06/08/2019

Aldi Distribution Centre (05_0142 MOD 2)

Request for Additional Information

PROPOSED OVERALL SITE PLAN
CAR PARK EXTENSION

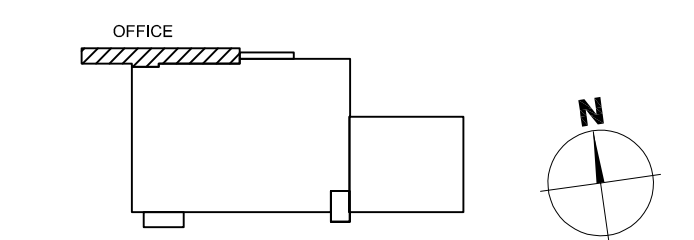
1. Clarification on car parking numbers, as the Statement of Environmental Effects, Traffic Impact Assessment and Site Plan detail inconsistent calculations of approved and proposed car parking numbers.
2. A revised Statement of Commitments to reflect any changes sought as part of this modification application.
3. The issues identified in Attachment 1, submission from the Environment, Energy and Science Group (ESS).
